**SUBJECT: BRES2308-0092
BUILDING RESIDENTIAL**

Here are the results of all Inspections located at **24 HAVERHILL PL:**

Inspection Type: ROUGH IN
Scheduled Date/Time: 3/18/2024
Completed Date/Time: 3/18/2024
Inspector: Justin Ryan McLeod
Result: DISAPPROVED

ROOF FRAMING PLAN

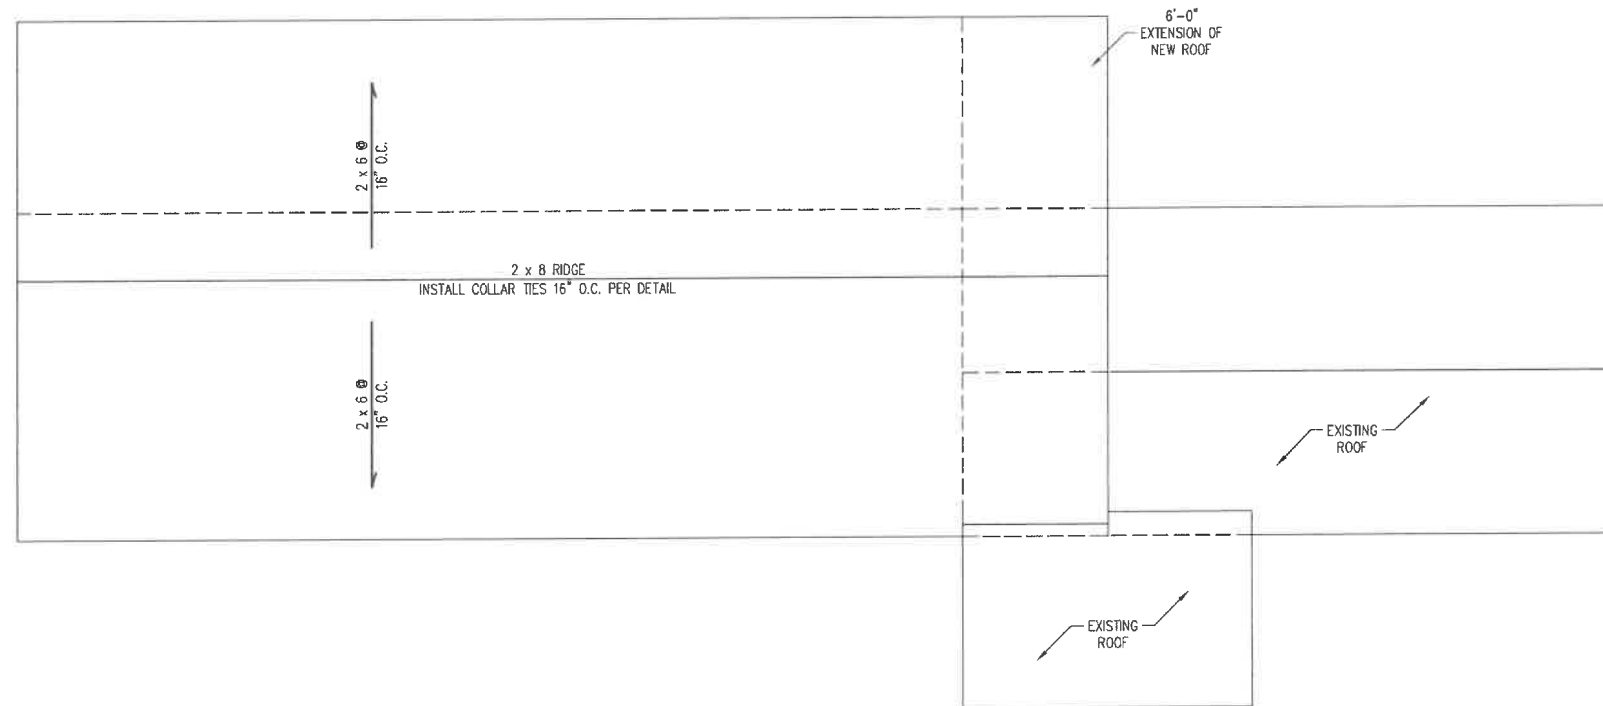
Notes: 1. 2x8 collar ties every rafter per plan. 2. Ceiling joists not referenced on plan, they cannot be supported by existing Mobil home wall without engineer saying it can. 3. The full span 2x12 on the left side that runs front to back is not on plan and is over spanned.
